Our ref: HMS ID 6271

Notice of Exhibition of application for an Environmental Impact Statement for the Powerhouse Ultimo Revitalisation (SSD-67588459)

7 June 2024

ELEVATION - EAST
SCALE: 1:200

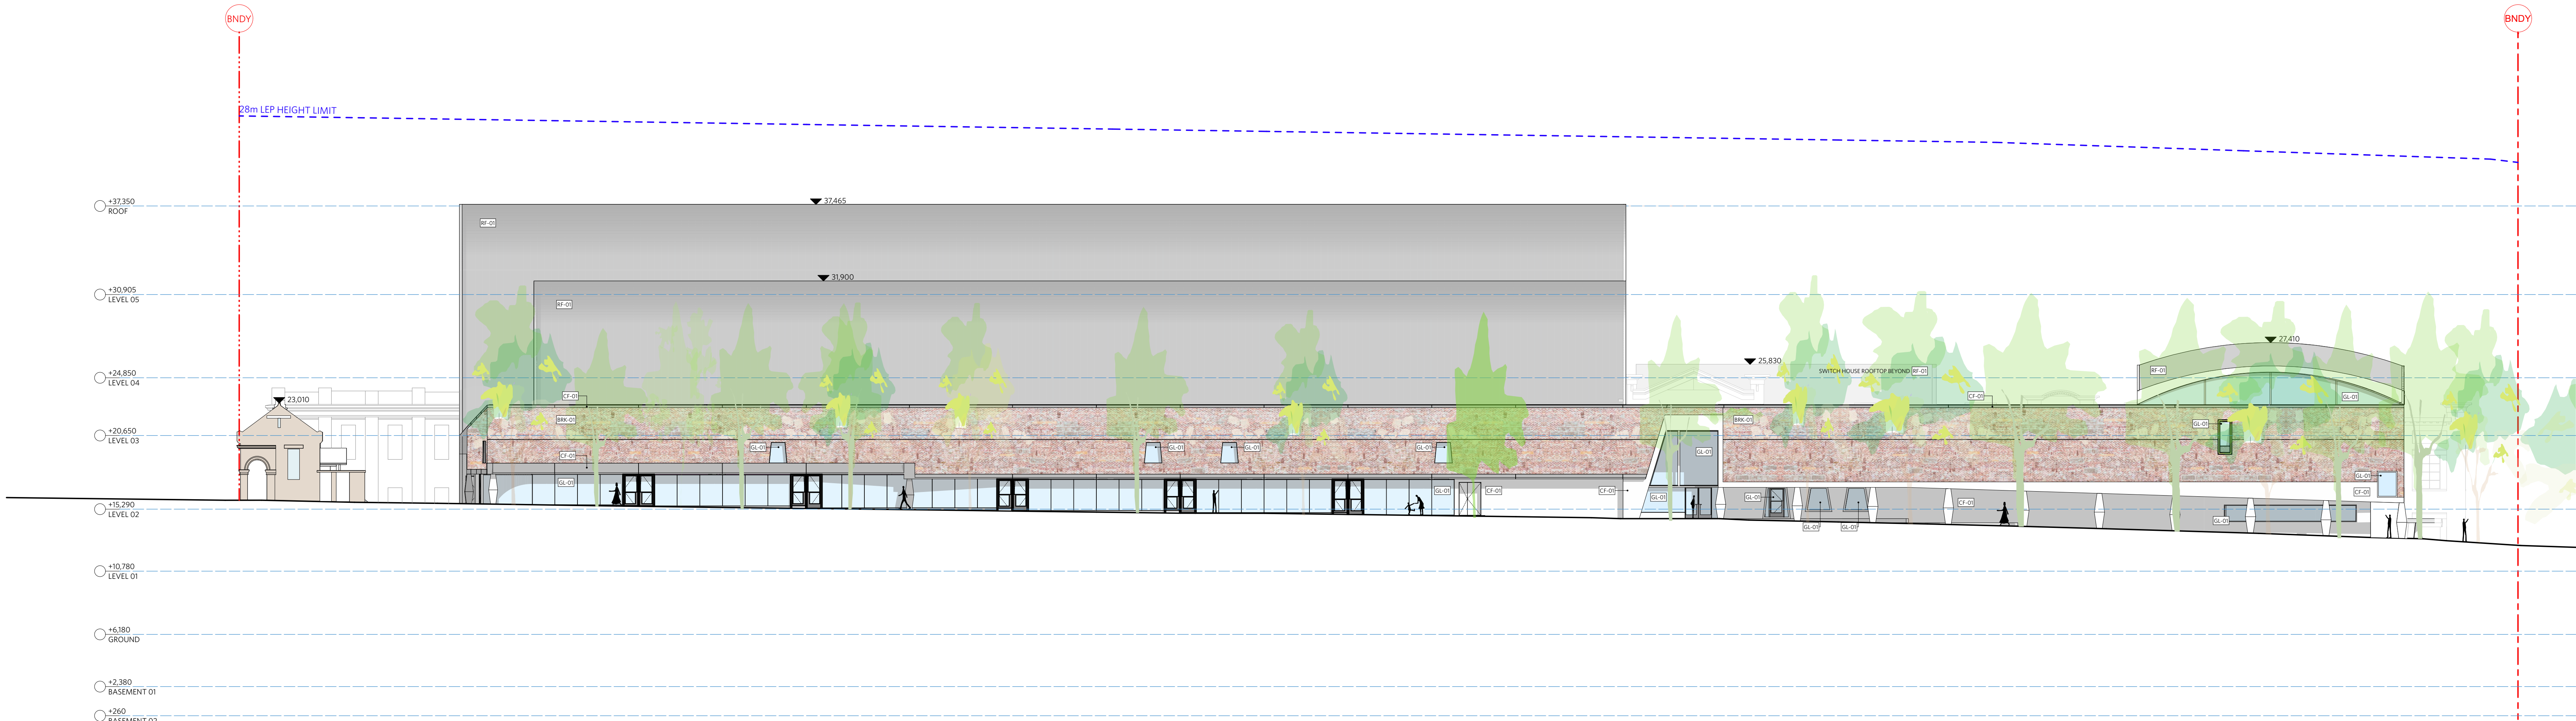
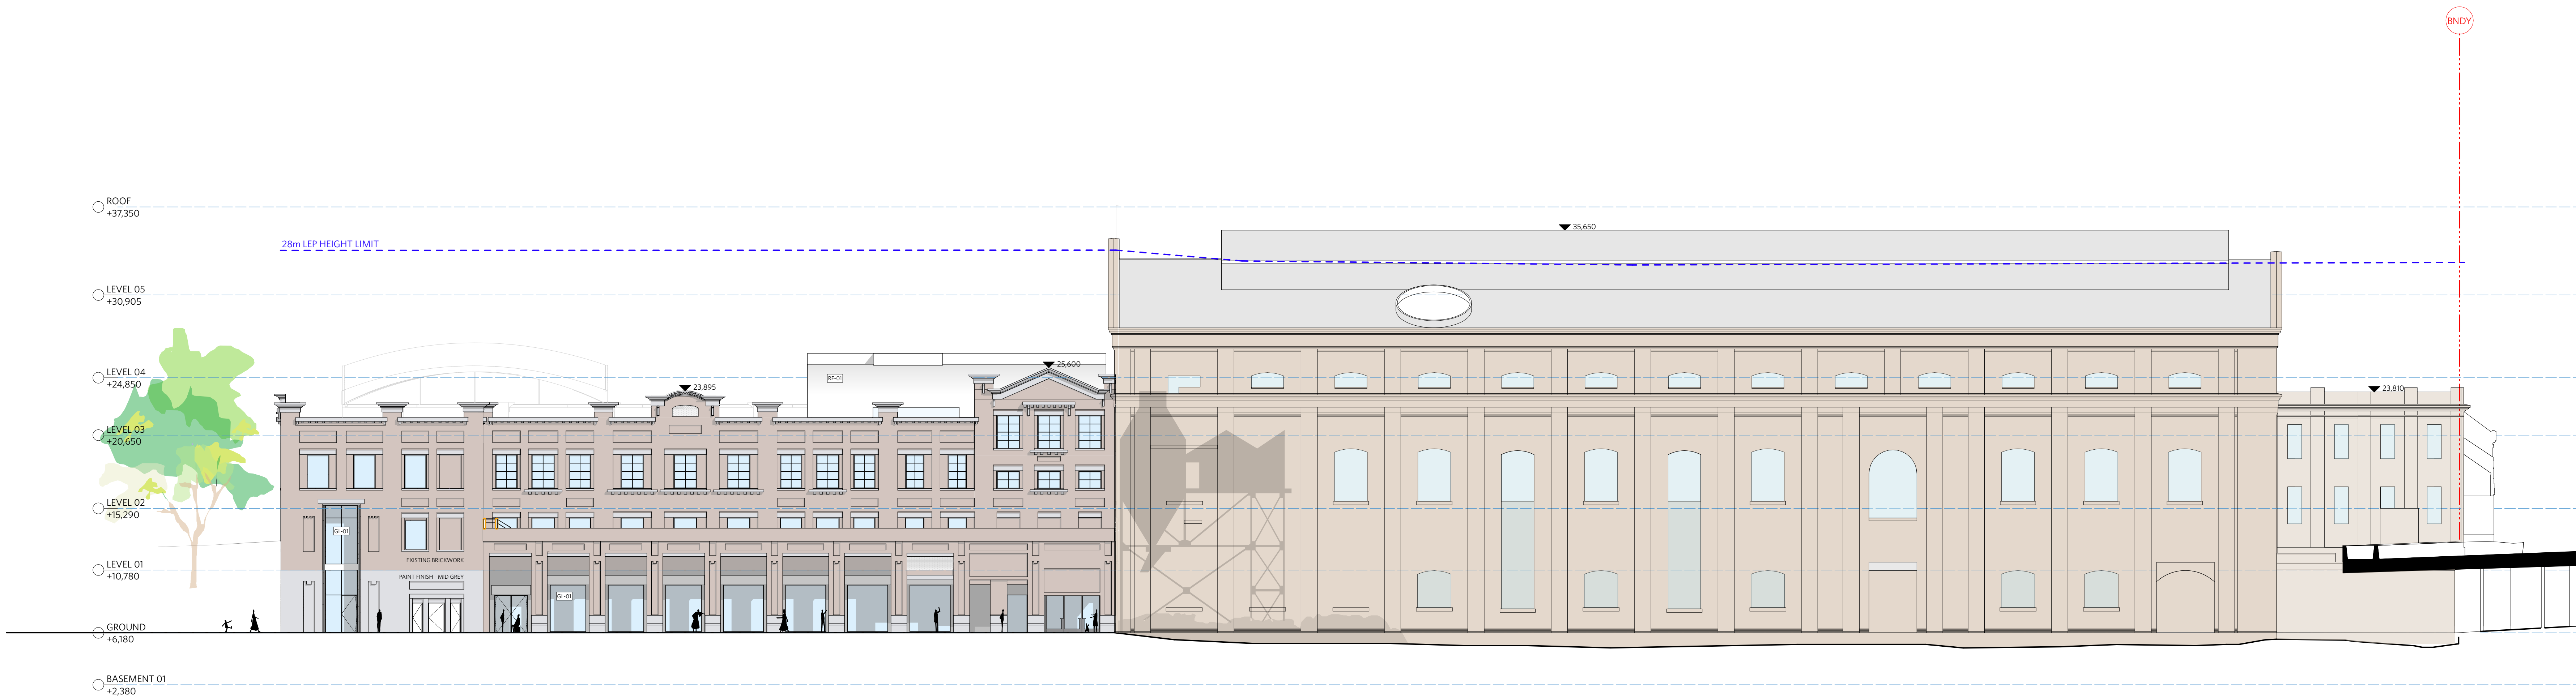
- The final design of the new museum addition along Harris Street will reduce any remaining views of the historic core from the corner of Harris and Macarthur Streets. The design should ensure that the facades to the new building are made more visually permeable to mitigate visual impacts. An updated Statement of Heritage Impact along with a revised Visual Impact Assessment demonstrating the impact of the final design could resolve and address these design issues.

- The final design should have regard to the legibility of the Wran building as perceived from the surrounding context and include appropriate setbacks. The use of common materials (recycled and reconstituted brick, stone and concrete) across both the Wran facades and the new addition along Harris Street is not supported. The Wran building reflects the distinct 1988 adaptive reuse development of the site as the PHM and the design should recognise this in terms of its external treatment/materiality. Further, it is claimed that the way the brickwork on the Harris St façade will be used reflects the geology/stratigraphy of the location of the PHM pre-settlement. How this is to be achieved requires greater explanation and tangible links to Connecting with Country principles.
